## *Rezoning Petition Review*

**Date of Review:** March 23, 2020 (***Revised April 16, 2020***)

**Rezoning Petition #:** 20-26

**Location of Property:** Approximately 7.53 acres located on the north side of Shopping Center Dr, east of Tryon St and southwest of Hampton Church Rd.

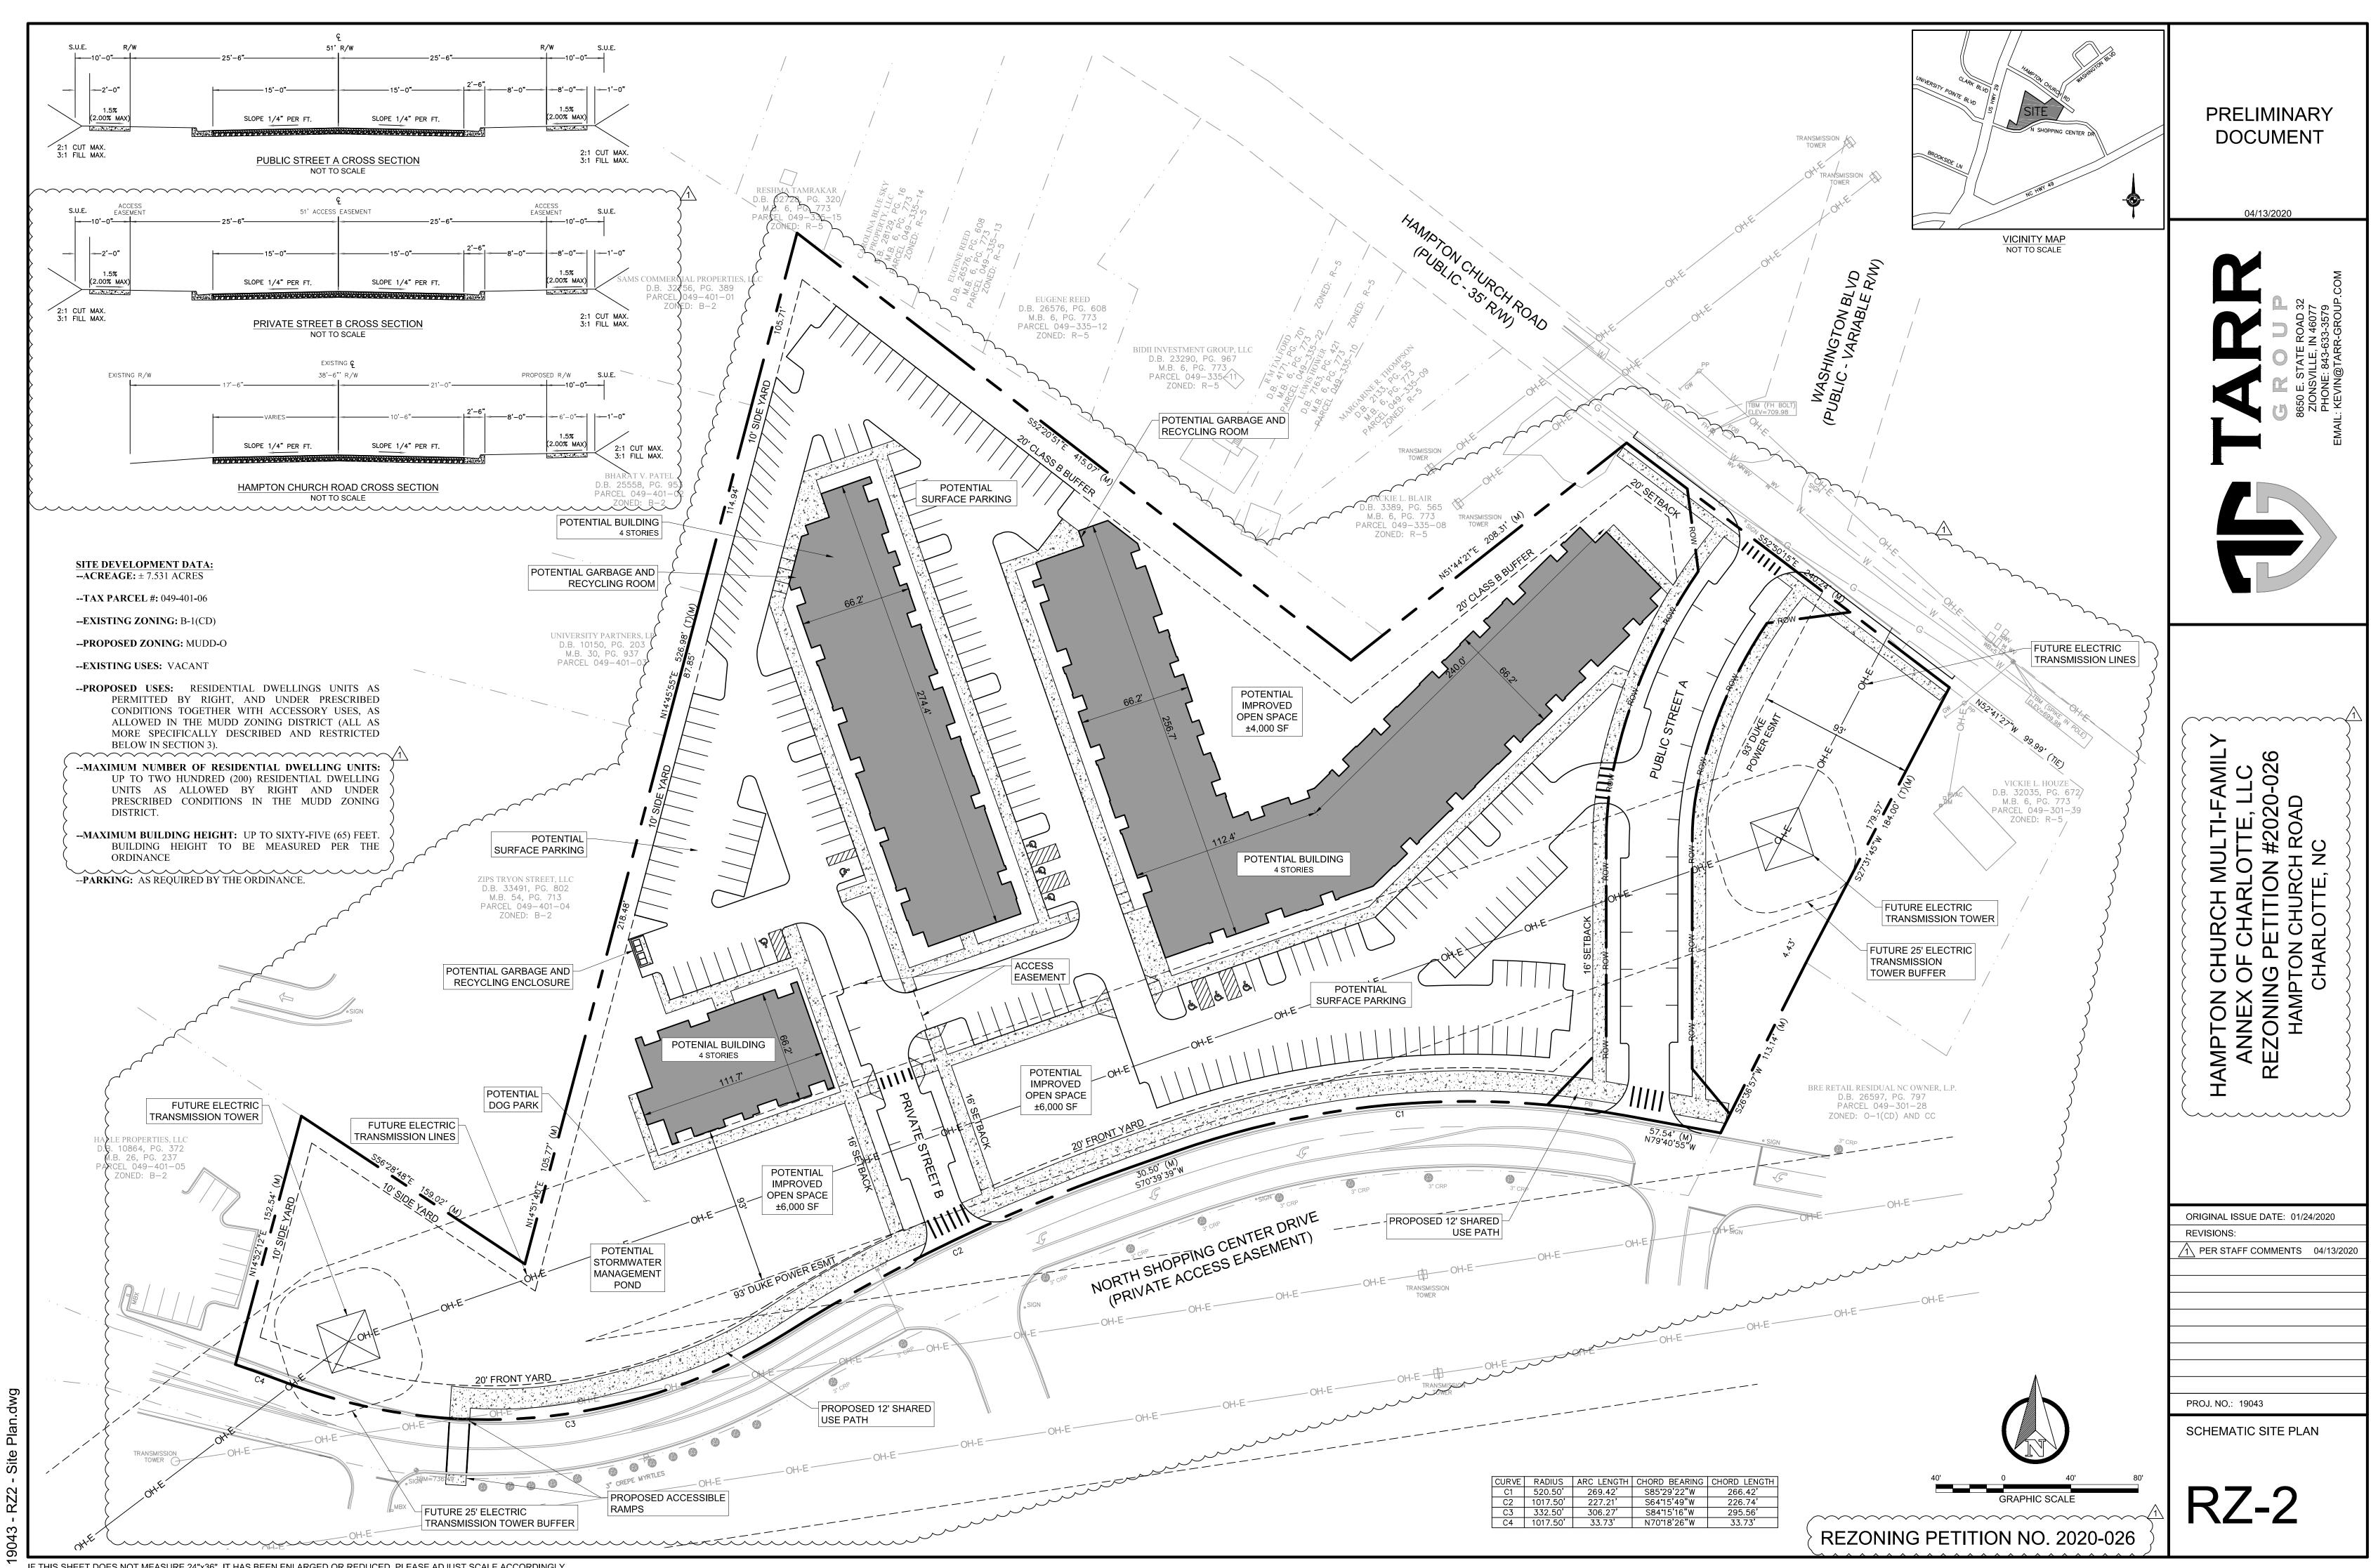
**Concerning Storm Water:** Under note 7a please revise *Post Construction Ordinance* to read *Post Construction Stormwater Ordinance*.

The proposed rezoning plan sheet indicates a proposed location for storm water management. Please include the following notes on the plan sheet under "Environmental Features": *The location, size, and type of storm water management systems depicted on the Rezoning Plan are subject to review and approval as part of the full development plan submittal and are not implicitly approved with this rezoning. Adjustments may be necessary in order to accommodate actual storm water treatment requirements and natural site discharge points.*
